**From:** Anthony.Collier@hertfordshire.gov.uk  
**Sent:** 30 June 2017 12:22  
**To:** Planning  
**Subject:** Planning application 6/2017/1273/COND - Hertfordshire Constabulary

**District ref:** 6/2017/1273/COND

Hertfordshire Constabulary  
Stanborough Road  
Welwyn Garden City  
AL8 6XF

Submission of details pursuant to condition 1 (parking during construction) on planning permission 6/2017/0504/FULL dated 01/06/2017

DRAWING TITLE
Existing Site Entrance Area

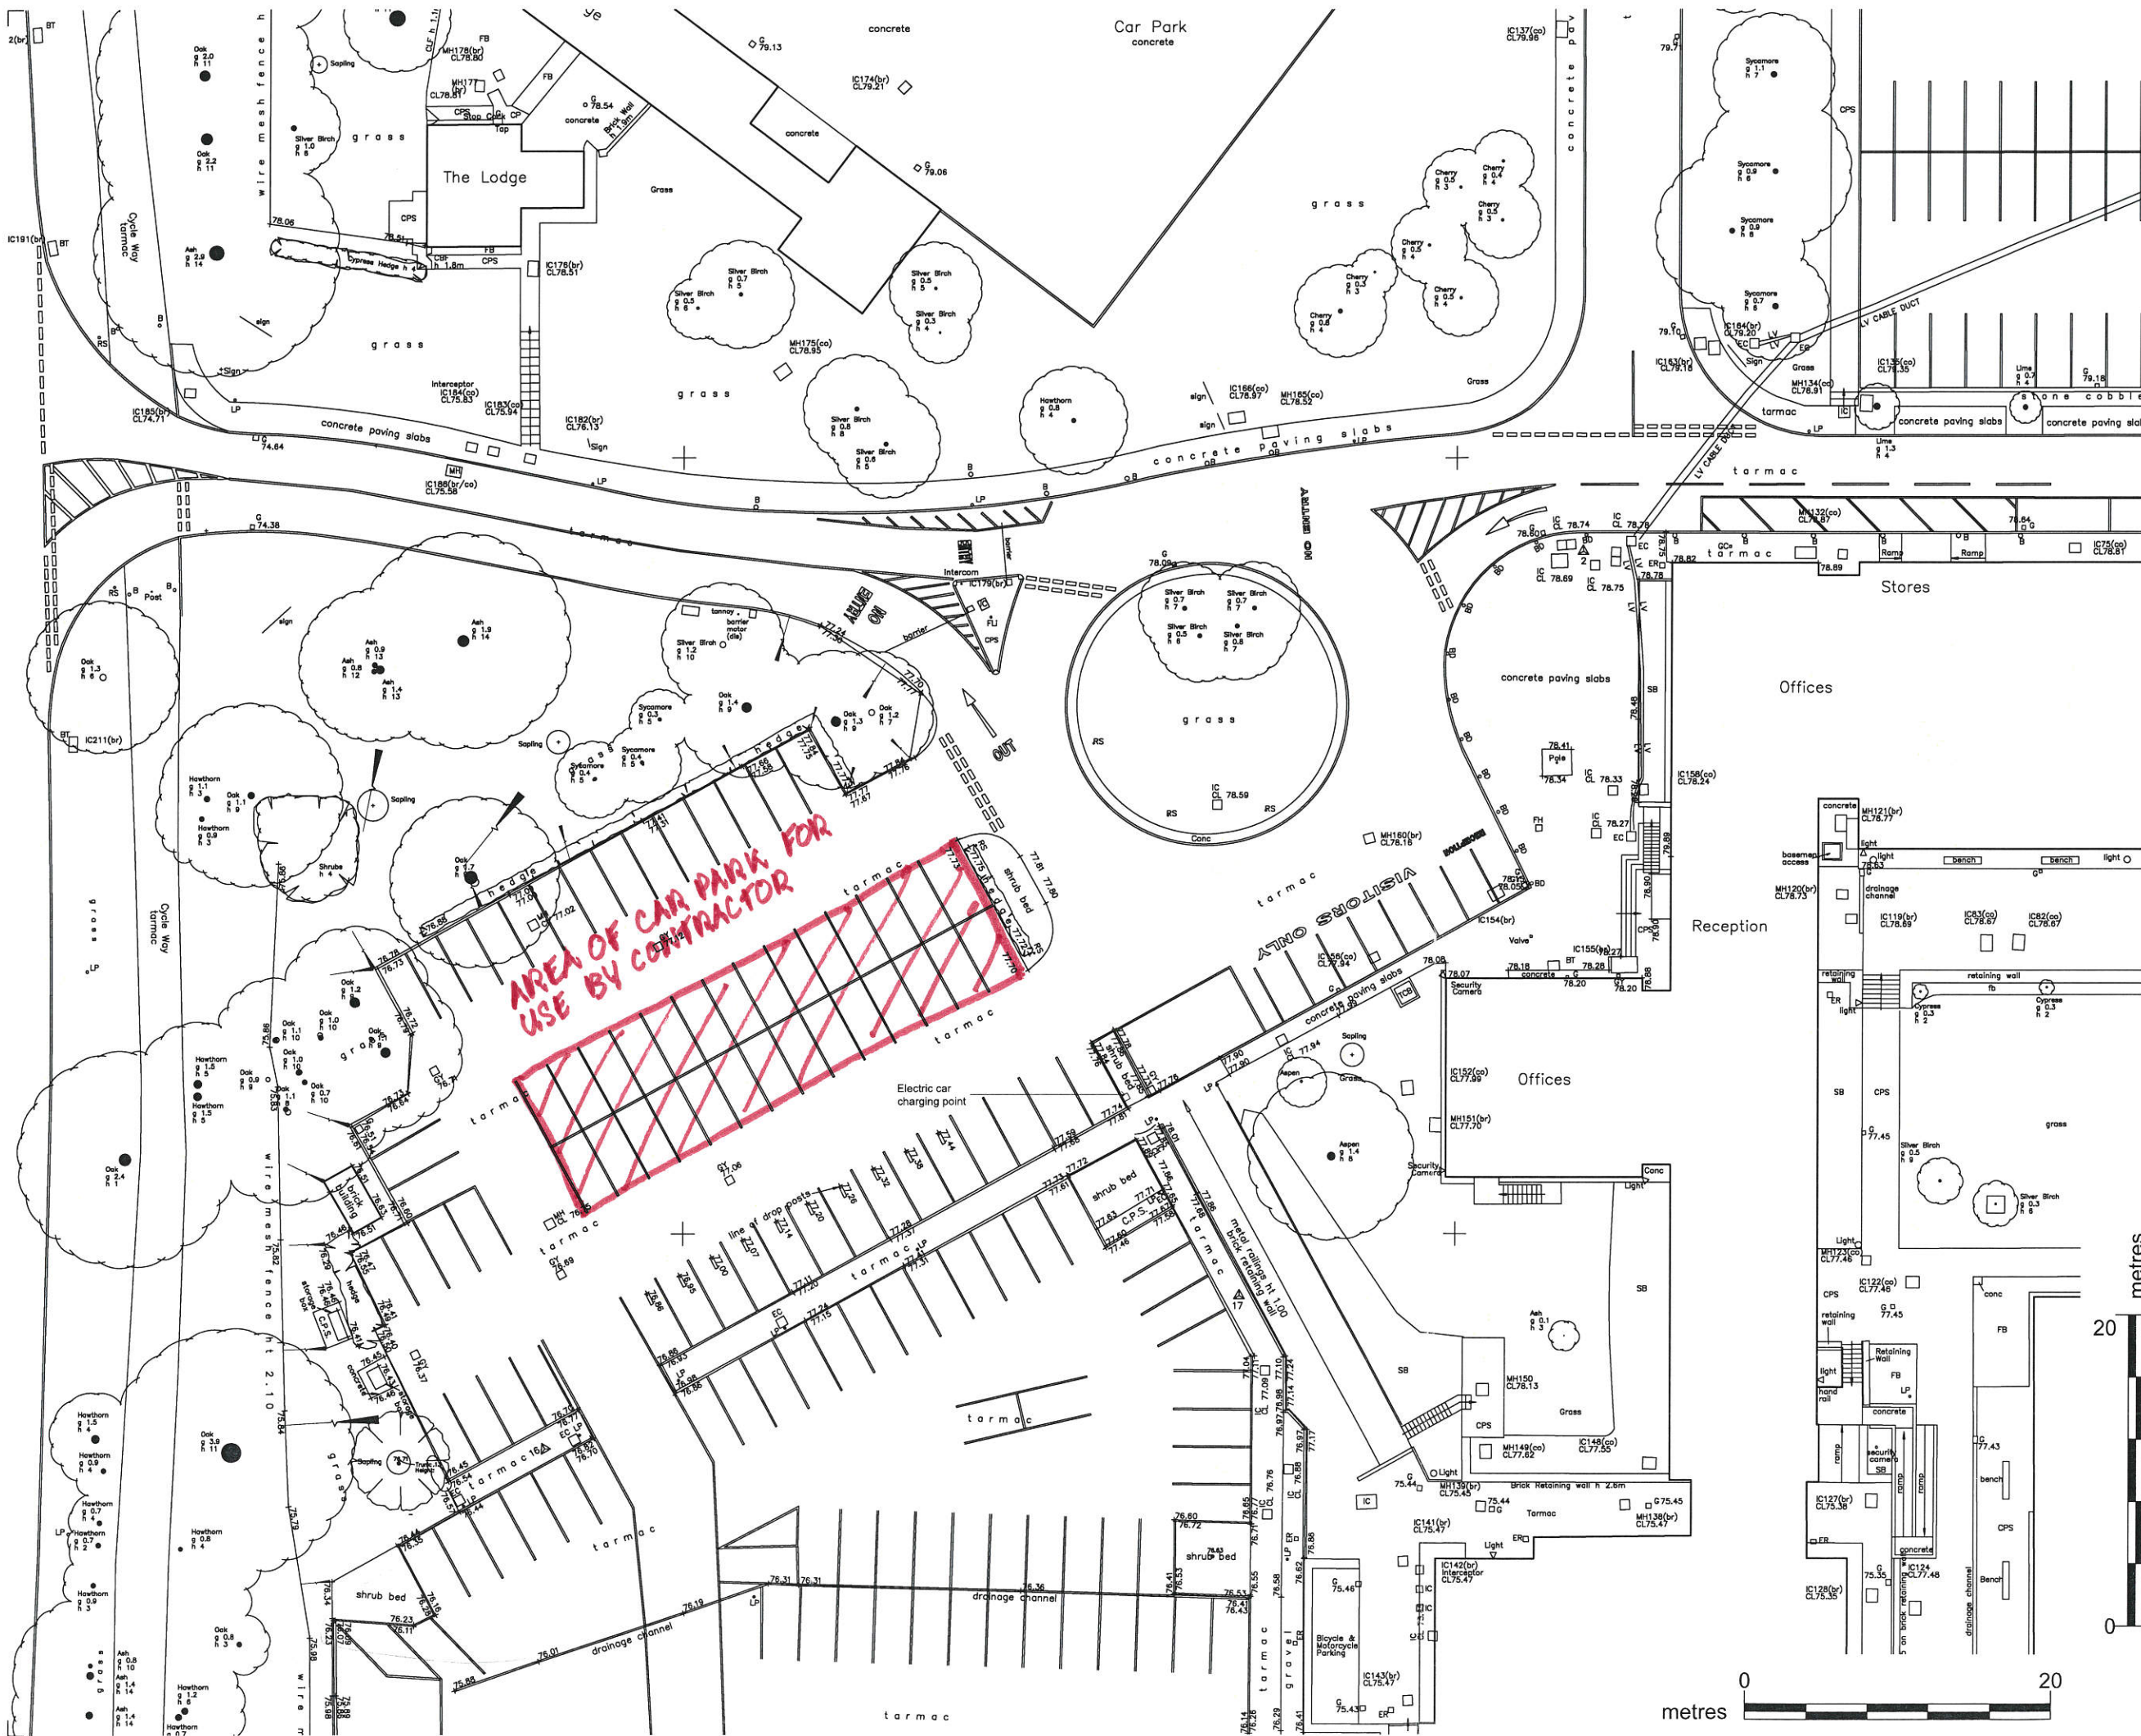
Adequate off highway provision is provided for the construction period, reducing the opportunity for traffic on the highway to be impacted during the construction.

it is therefore deemed that the condition should be granted.
